MEMORANDUM

SUBJECT: CDR-18-003 – Lorson East – Fontaine Blvd.
First Submittal

**FONTAINE BLVD
SIGNING & STRIPING PLAN**

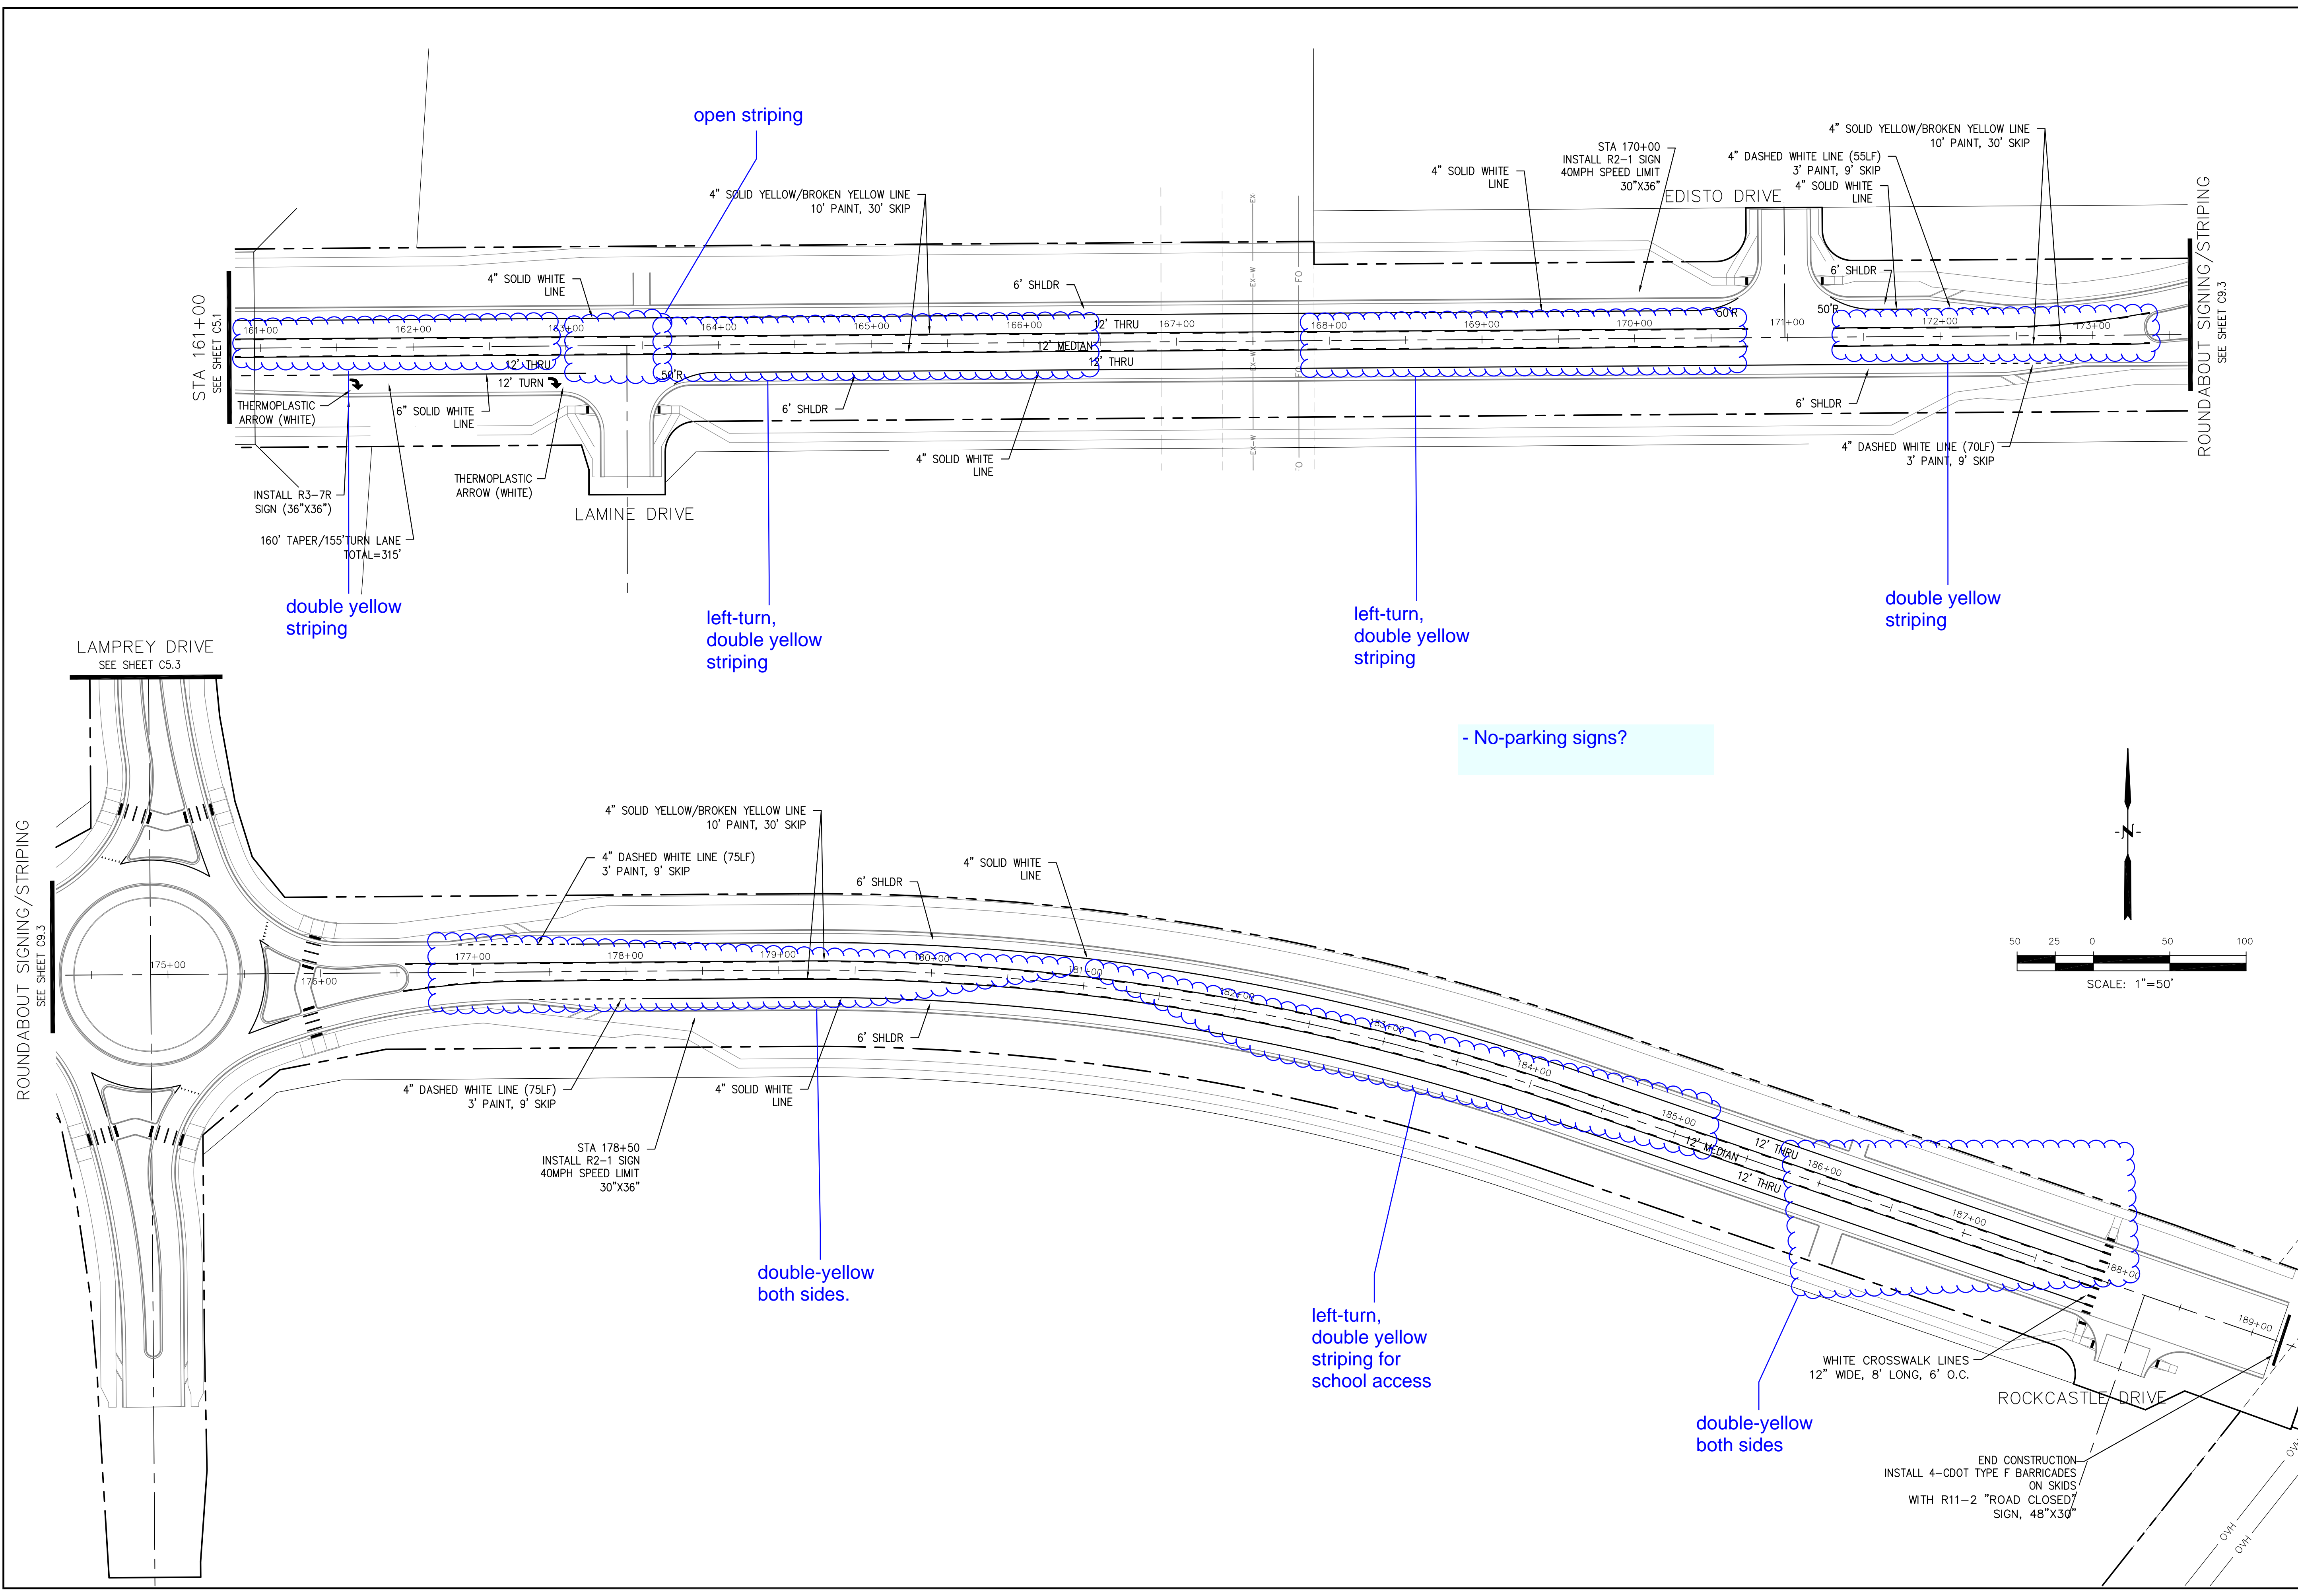
1. The east side of the Fontaine/Stingray/Old Glory intersection needs to be adjusted to add a through-lane split further east, then the turn lane splits where shown (see redlines). *RE: lane added*

ROUNDABOUT DETAILED GRADING
FONTAINE BOULEVARD
SOUTH HALF

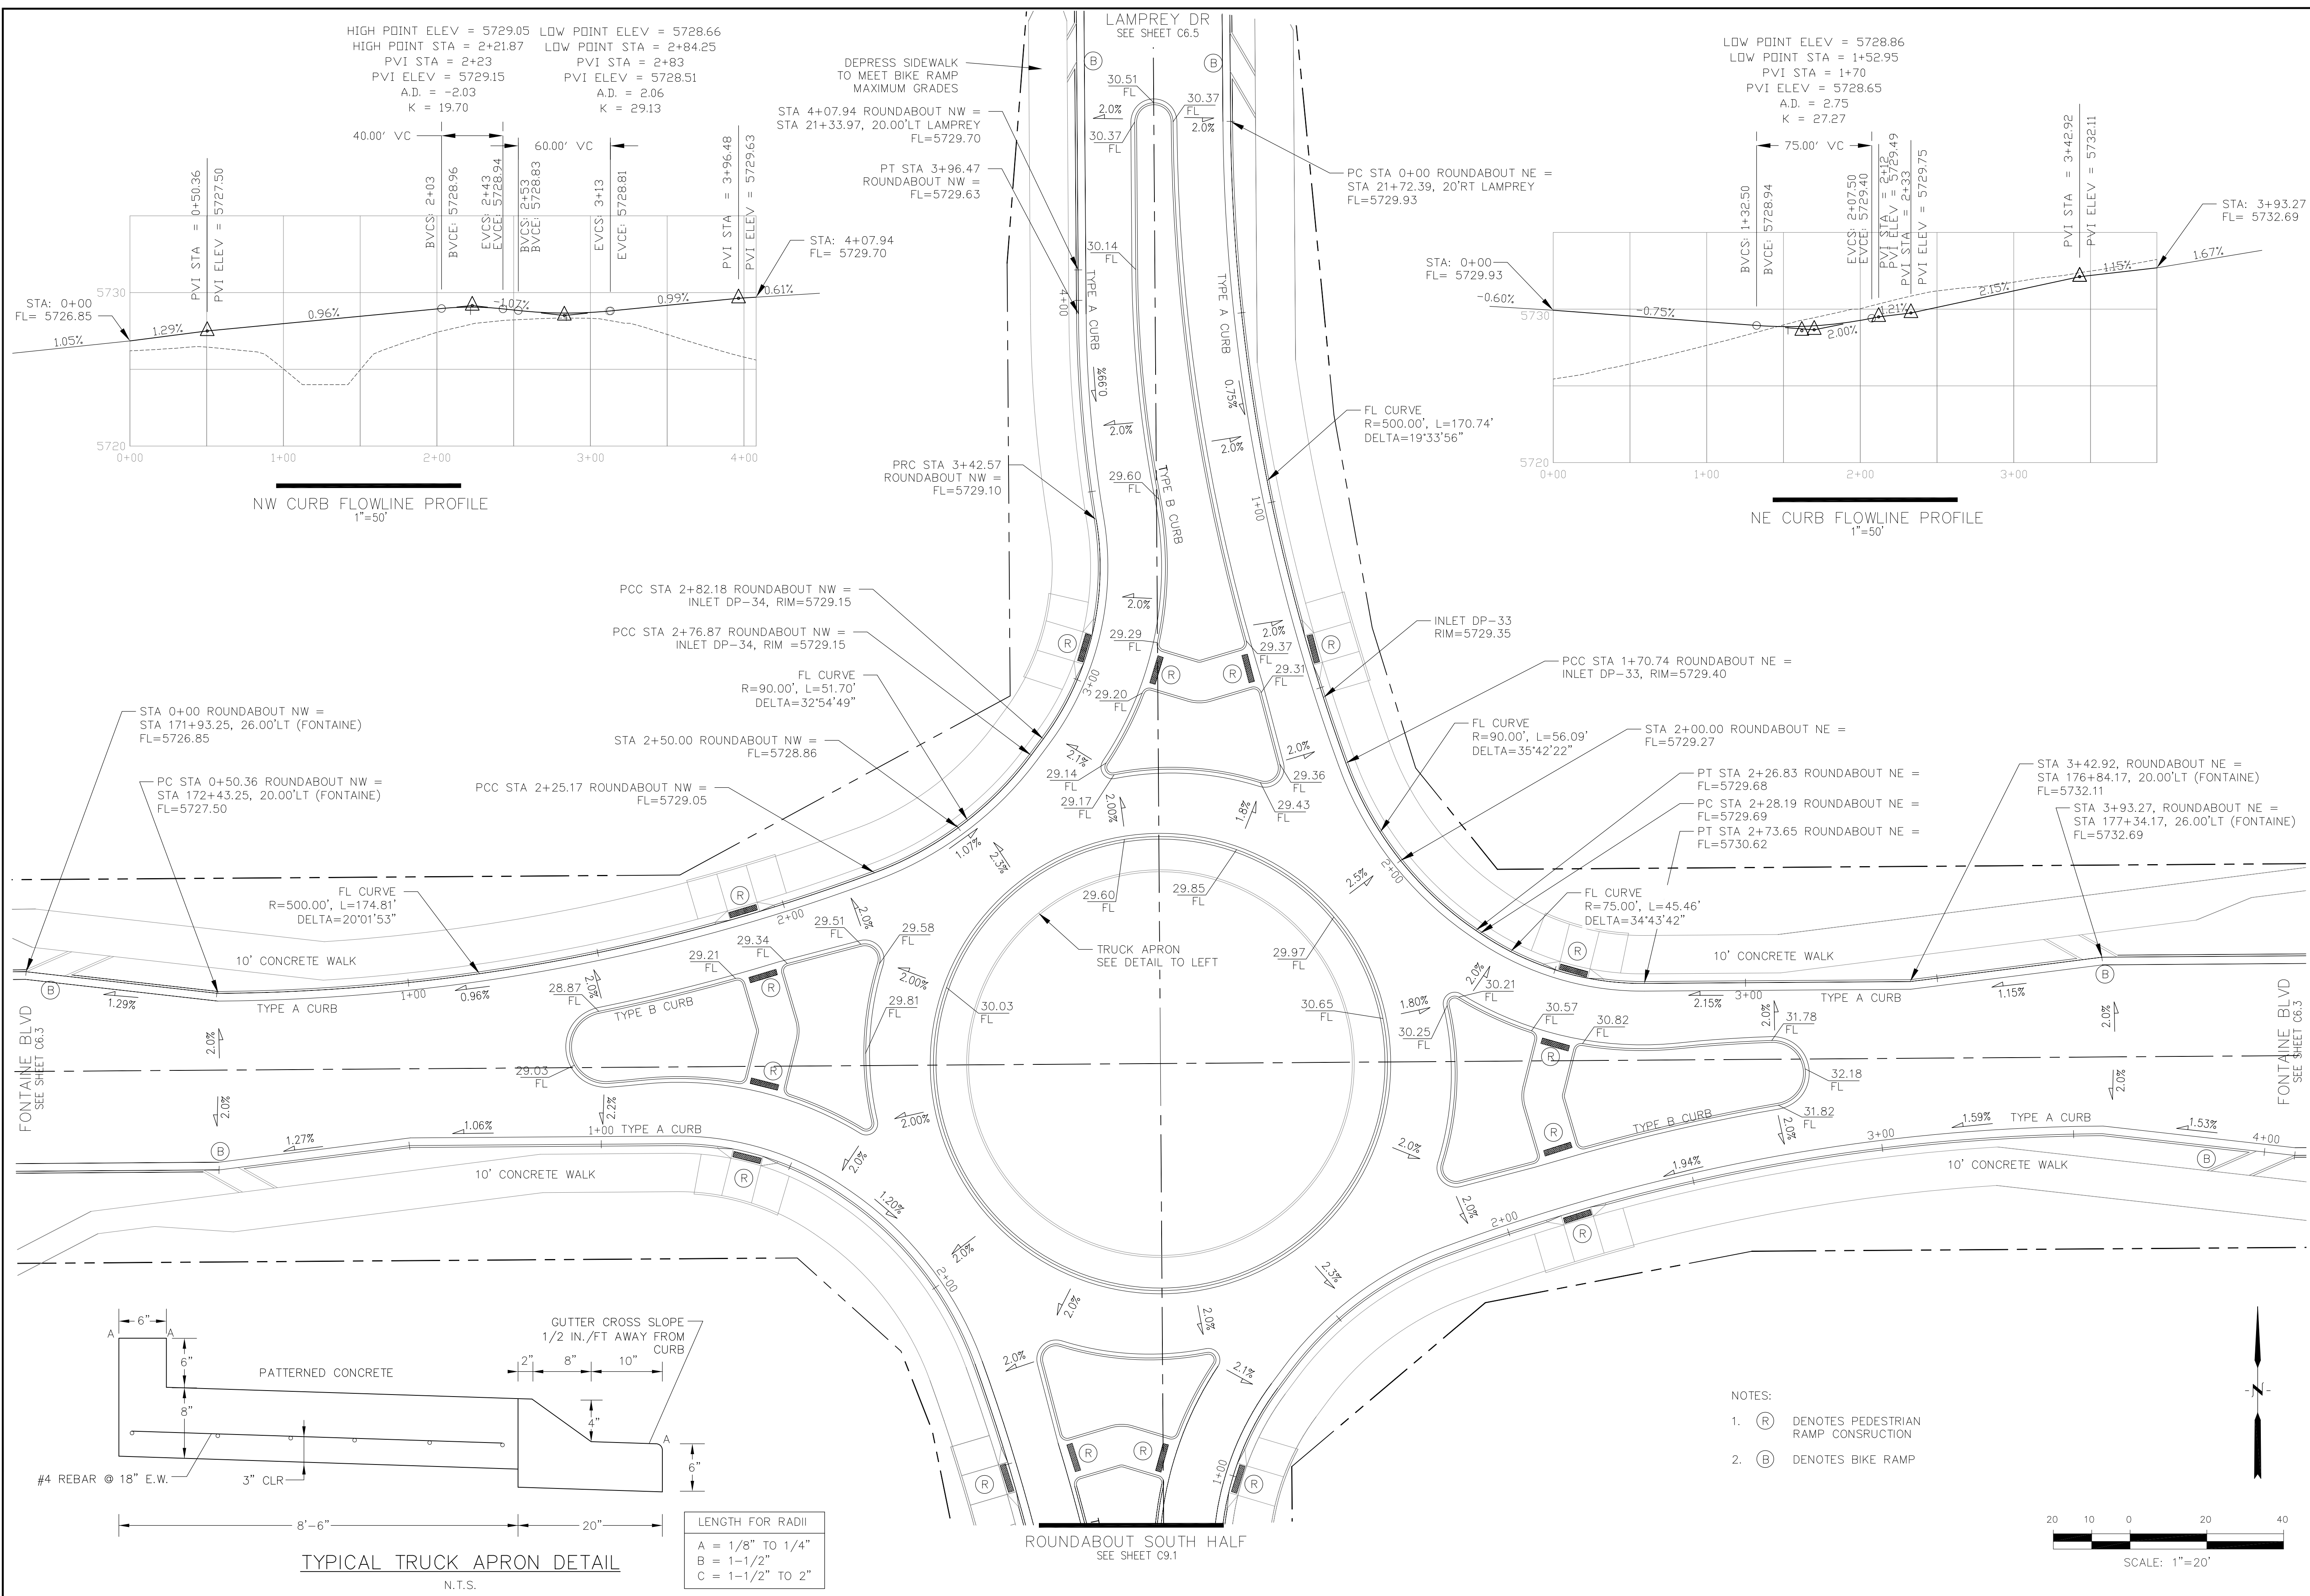
5. Revise the roundabout entry angles, which should be between 20° and 30°, as appropriate. *RE: entry angles recalculated*
6. See electronic redlines for additional comments and further revisions. *RE: noted*
